FIRE RISK MANAGEMENT, INC

Memo Report

Subject: Code Review; ICW Proposed 133 York Street Apartment Building Site Access

SITE PLAN MAP 44/BLOCK A/LOTS 29 & 31

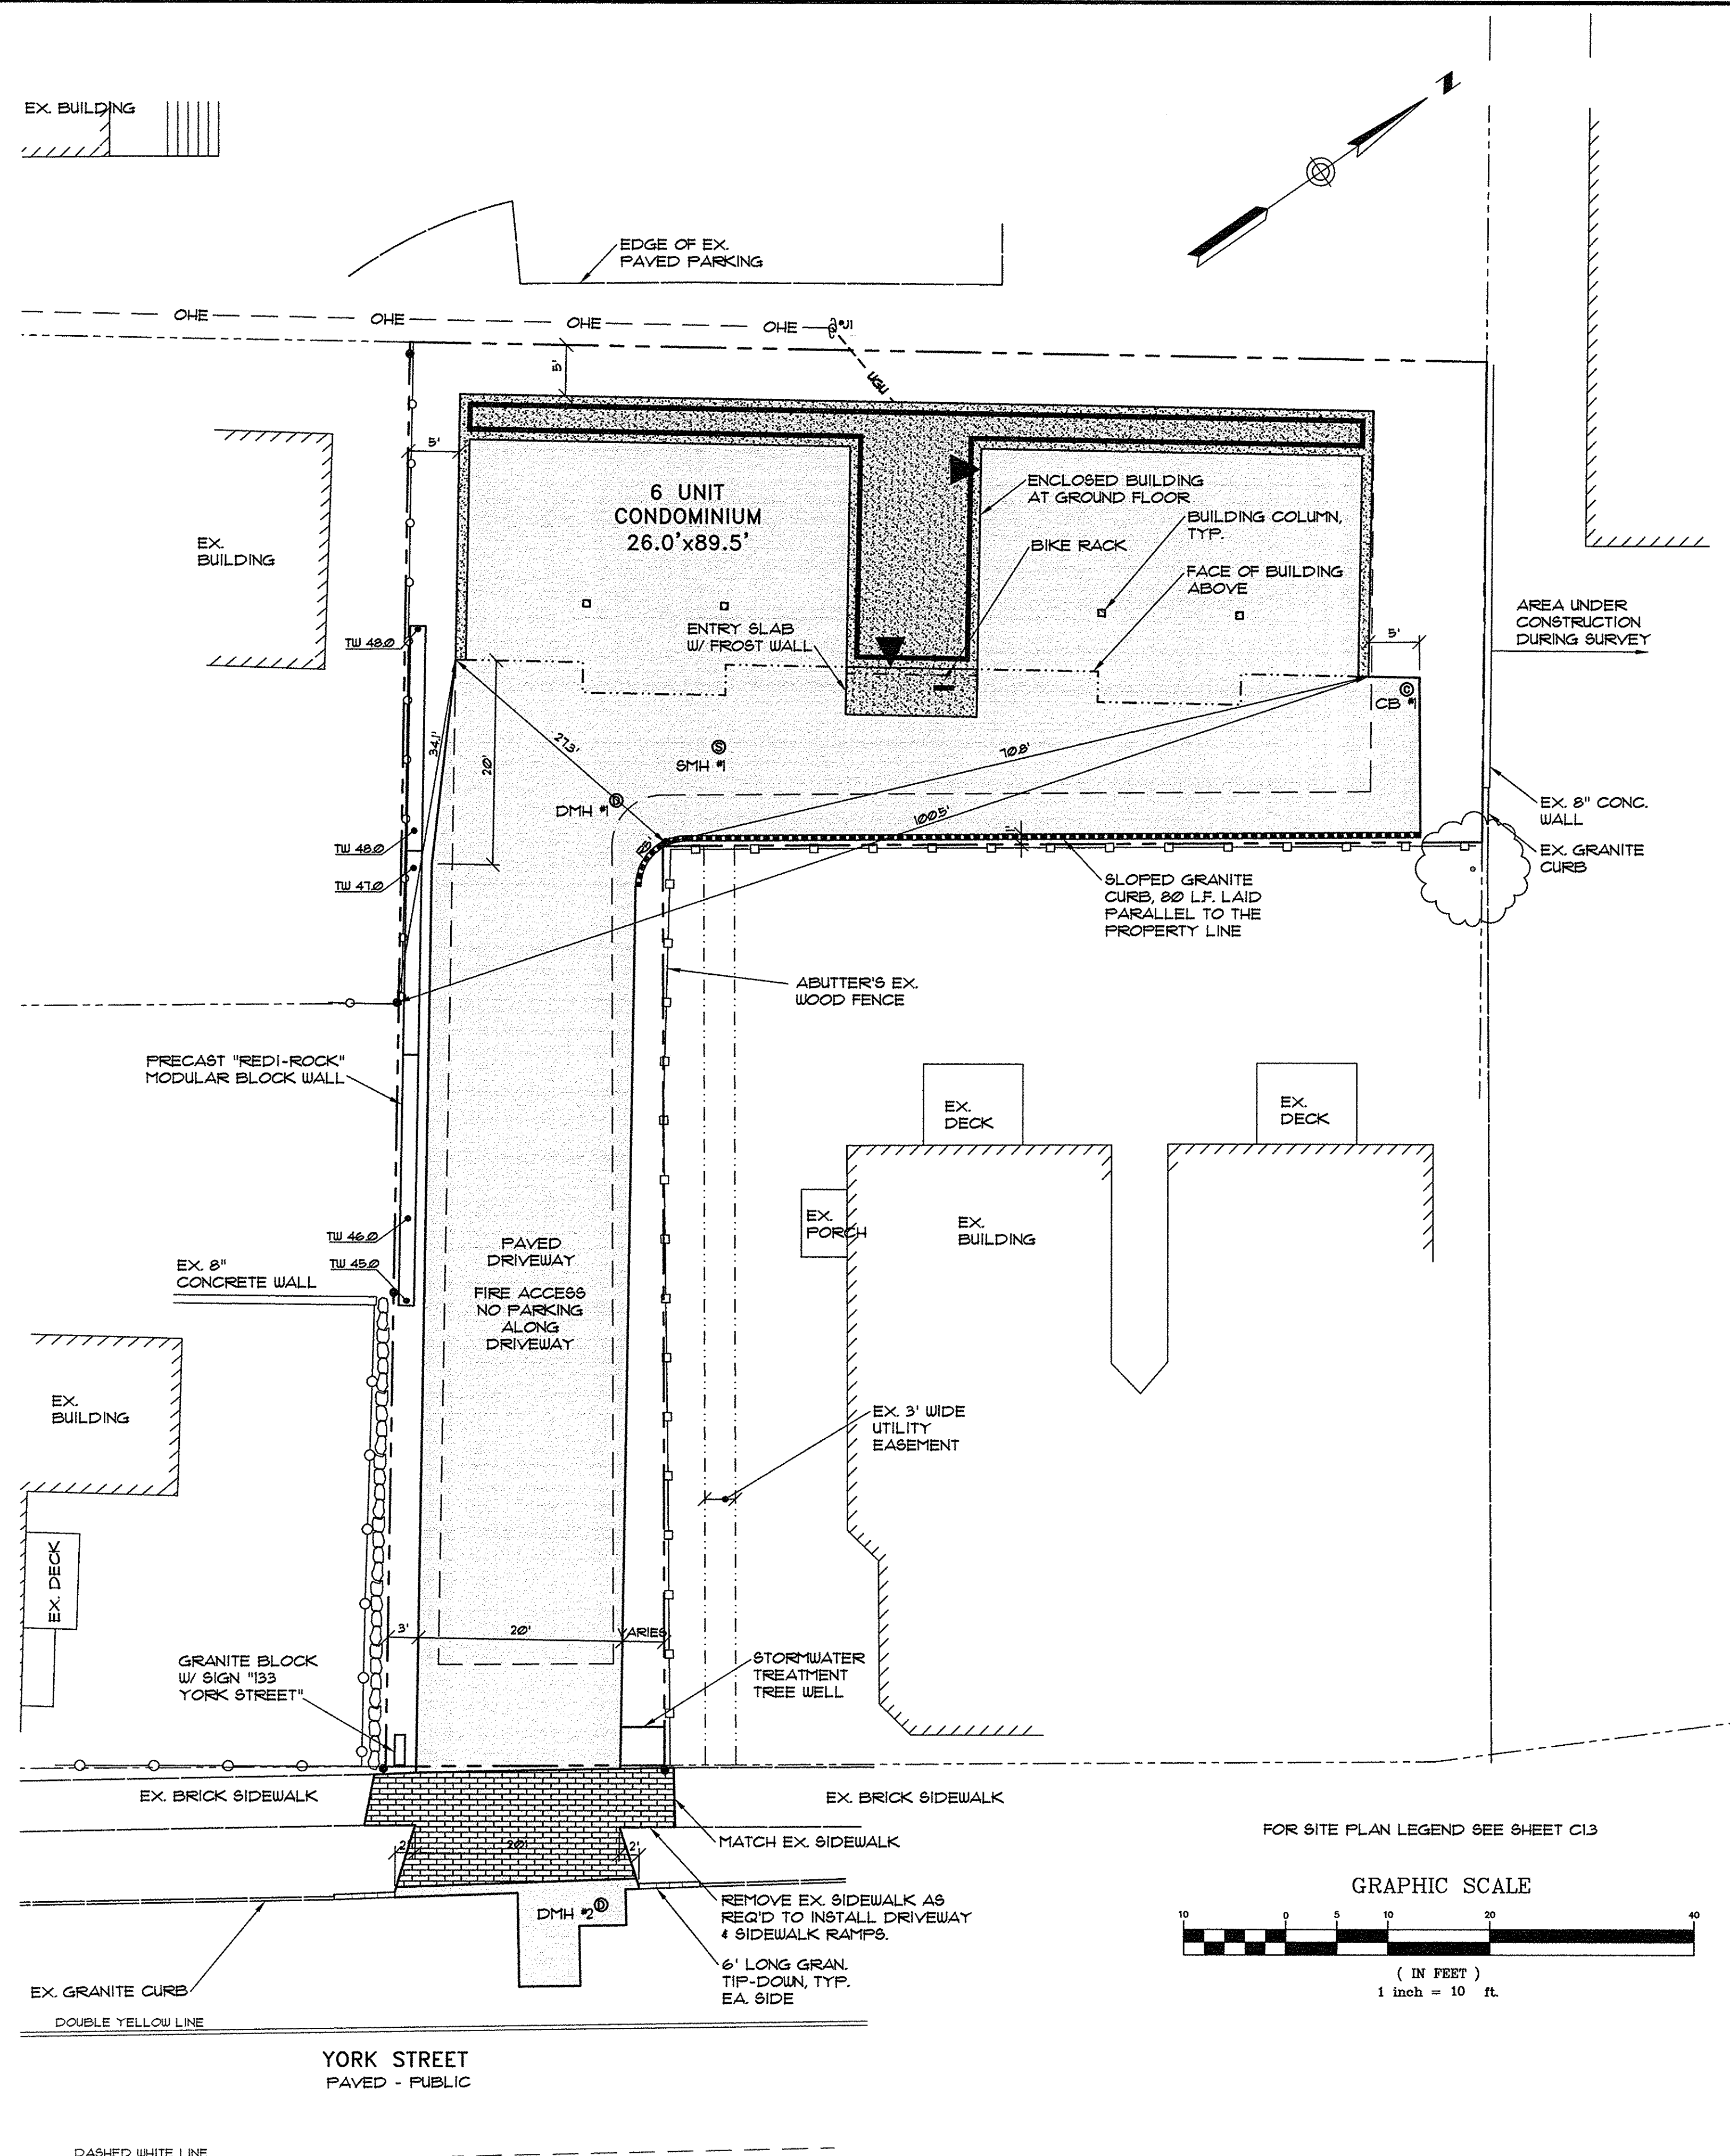
- *The access road must be at least 16 feet in width to meet City requirements.* The NFPA 1 would require this access road to have at least 20 feet in clear width. The driveway (access road) shown on the site plan will provide up to 20 feet of clear width.

- *Any dead-end access roads in excess of 150 feet must be provided with an adequate turn-around area.* Since the turn radius from the driveway into the parking lot area is not sufficient to accommodate fire department apparatus, this access road is considered a dead end. The distance from the street to the front wall of the building is less than 120 feet. As such, this access road is not required to be provided with a turn-around area. The access road is completely straight and should not present much of a challenge for fire department personnel to back the apparatus out of the driveway once firefighting operations are complete.

- *At least one (1) fire hydrant must be within 250 feet of this site. The City also has a requirement that a hydrant must be within 100 feet of any Fire Department Connection (FDC).* A fire hydrant is located at the corner of Park and York streets. This location is easily within the 250 foot limit. However, the distance from the hydrant to the likely location of the building's FDC, when following the likely route for laying hose, will be outside the 100-foot limit.

- *Based on the construction type(s) of this building, NFPA 1 would require a minimum fire flow (fire water supply capabilities) of at least 1750 gpm.* The fire hydrant that is located at the corner of Park and York streets has a "light blue" bonnet; indicating that it can support fire flows in excess of 1500 gpm. Although recent flow test data for this hydrant were not reviewed as part of this evaluation, past experience with flow data in this area of Portland has indicated that it is highly likely it can easily support the 1750 gpm requirement for this building (at a minimum of 20 psig residual pressure at the hydrant).

Based on a review of both the building and its site plan, along with comparing these data to the requirements needed to support fire department operations, the design plan for this building appears to be generally compliant. The only item that will require further design attention is the need to have a fire hydrant within 100 feet of the building's FDC.

With the exception of the distance between the closest fire hydrant and the building's FDC, the site design plan for this building should meet all requirements for site access and water supply as outlined in both NFPA 1 and the City's Fire Department Rules and Regulations. To support the distance requirements between a fire hydrant and the FDC, two options exist; 1) install a new, private fire hydrant in the vicinity of the building, such that it will be within 100 feet of the planned location of the FDC, or 2) install a remote FDC near the end of the access road. In either case, measures must be implemented to ensure that the hydrant or FDC are protected from damage and remain accessible, including during the winter months.

Although the access road will meet the minimum width requirements, it will also be necessary that "No Parking" signs be placed along this driveway to ensure that it always remains clear.

The actual fire hydrant flow test data for the hydrant located at the corner of Park and York Streets should be reviewed to confirm it has the capability to support the fire flow requirements for this building.
